Our Ref: AWE200083-L01: BCP/bcp
Contact: Dr Brett C. Phillips

22nd February 2021

RESPONSES TO FLOODING SUBMISSIONS, ASPECT INDUSTRIAL ESTATE, KEMPS CREEK, NSW

Figure 35 500 yr ARI Flood Hazards - Stage 1 Conditions

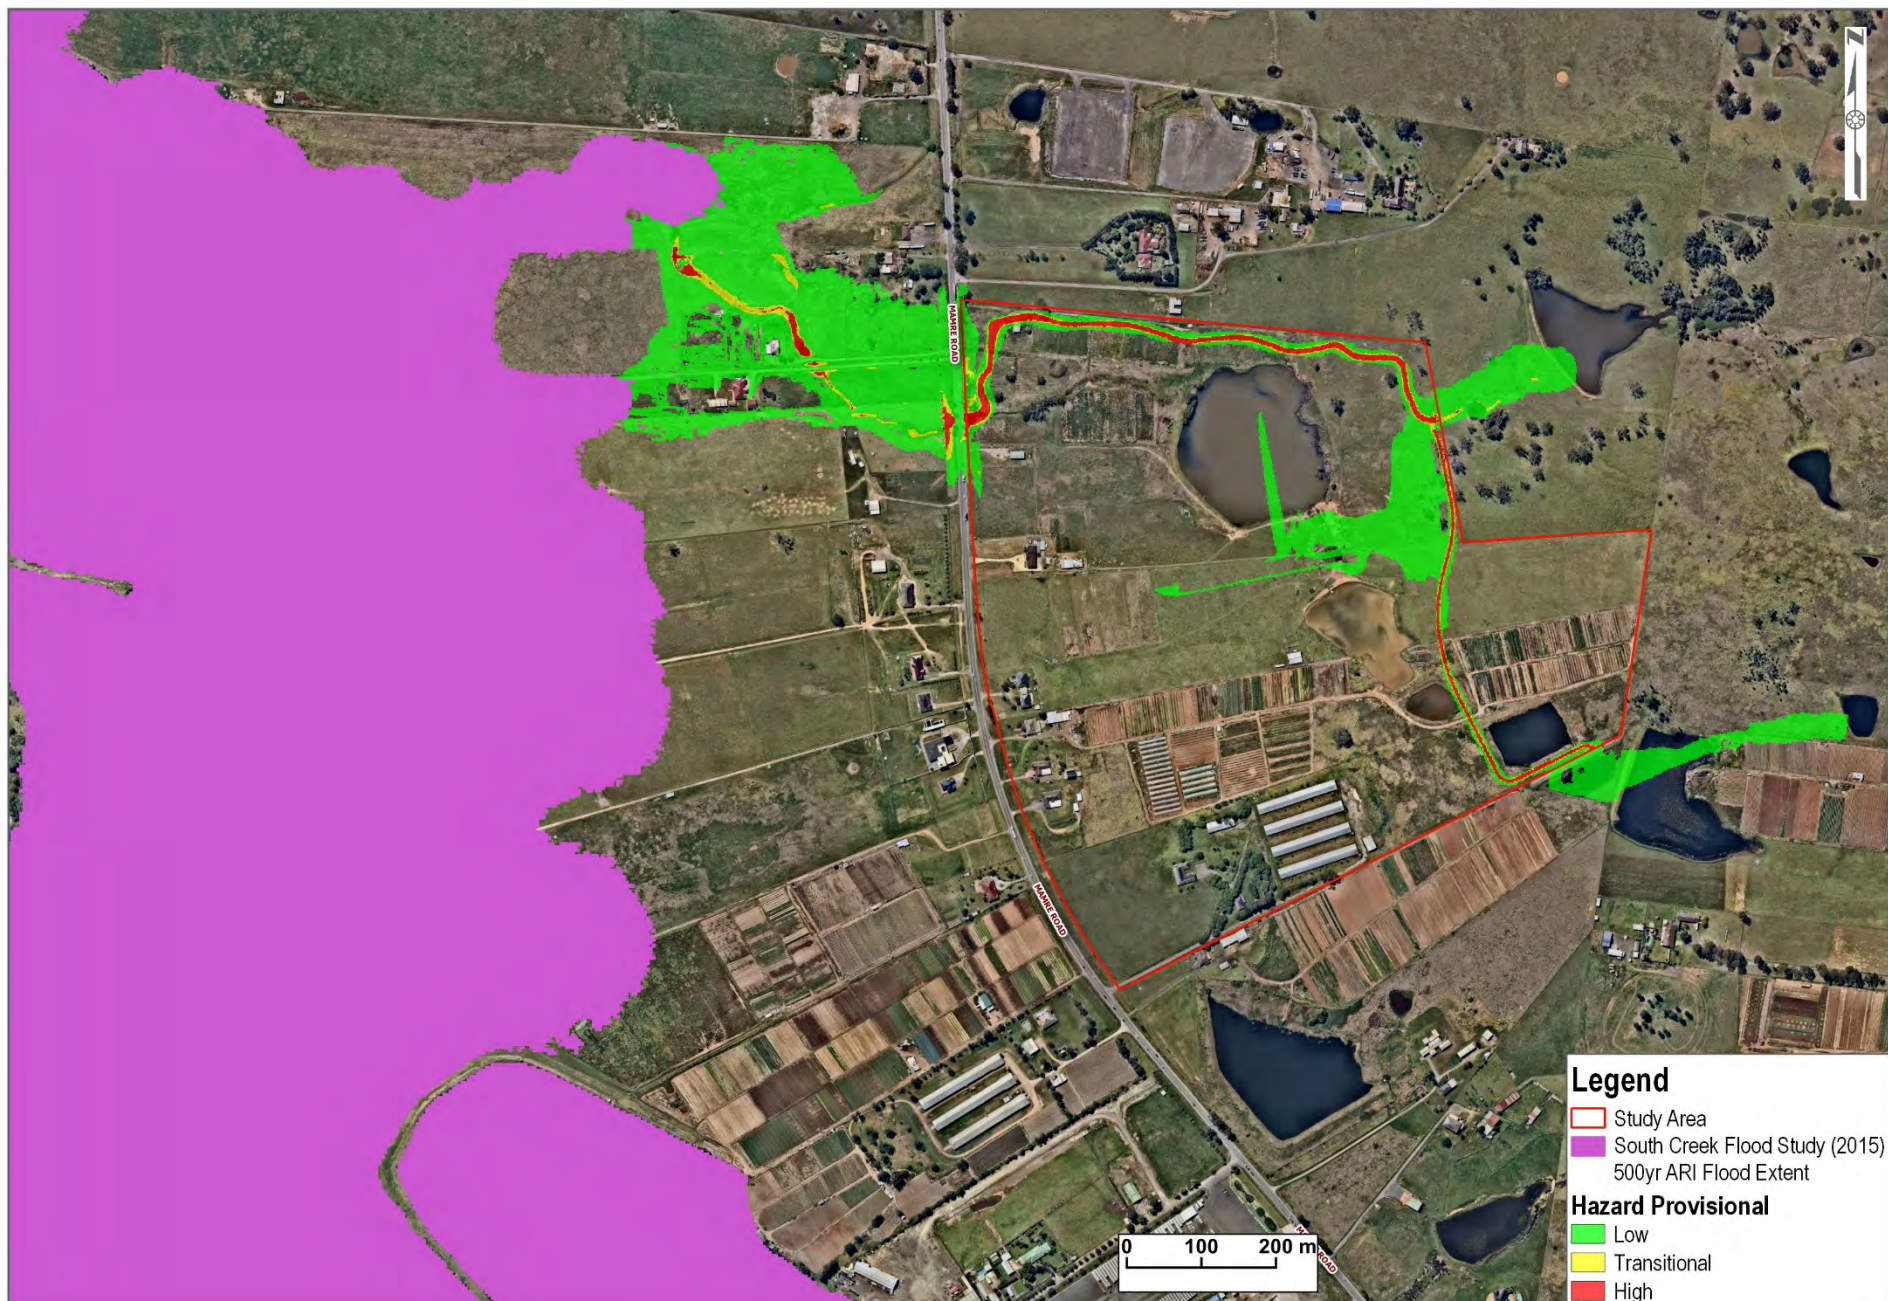
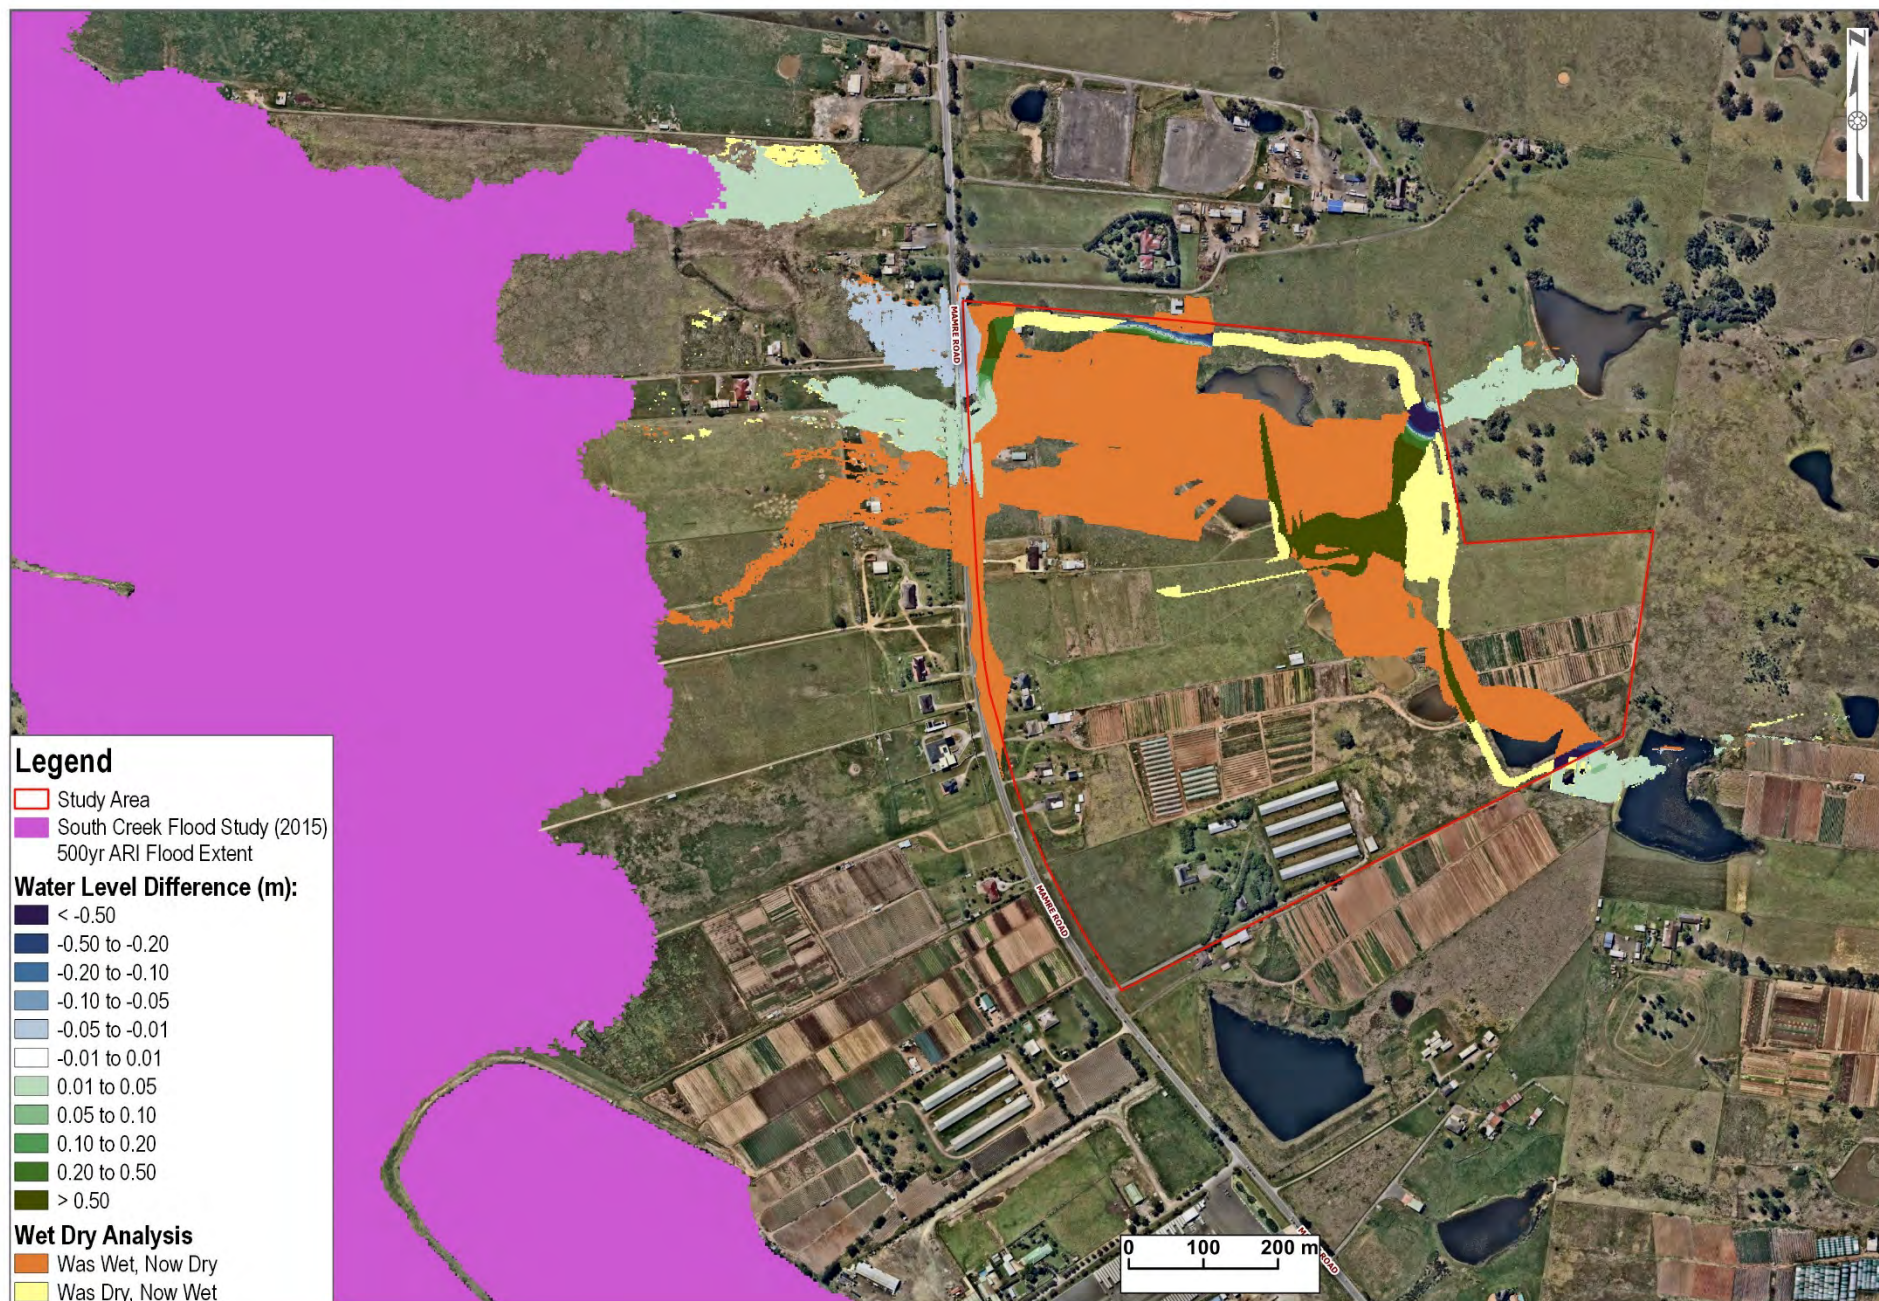
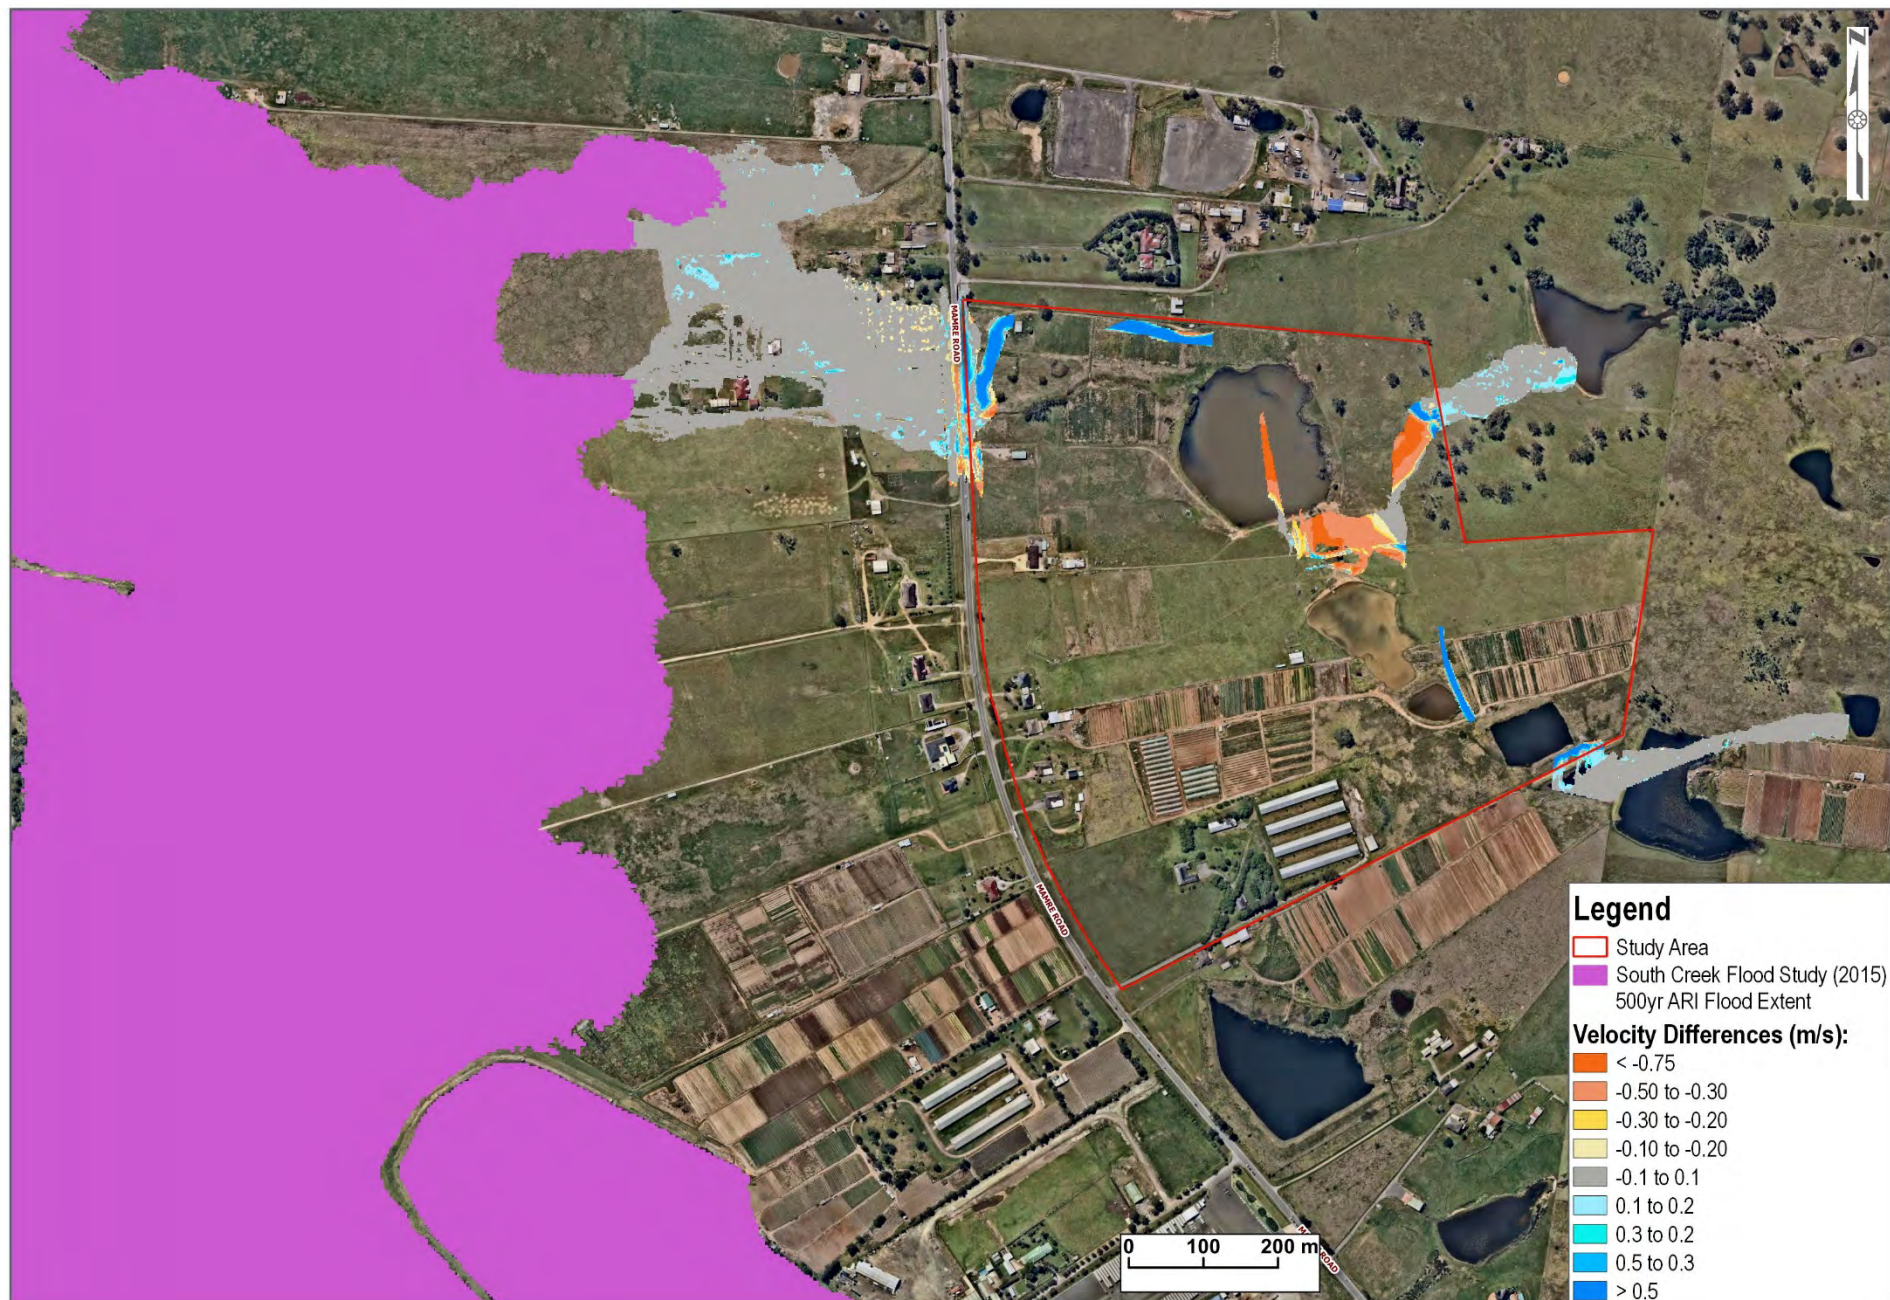
- *The developed scenario maps present local overland flow for Stage 1 which comprises of two industrial lots on the northern part of the site. However, from a flow management perspective, an overland flow study should consider the ultimate developed scenario of the site instead of considering each progressive development independently.*

- *All maps for developed conditions should properly depict the layout of the development, locations of proposed constructed channels and the location of the proposed detention basin.*

The final masterplan has been assessed and the results of the assessment have been incorporated into an updated version of the FIA report.

The updated Figures have been incorporated into an updated version of the FIA report.
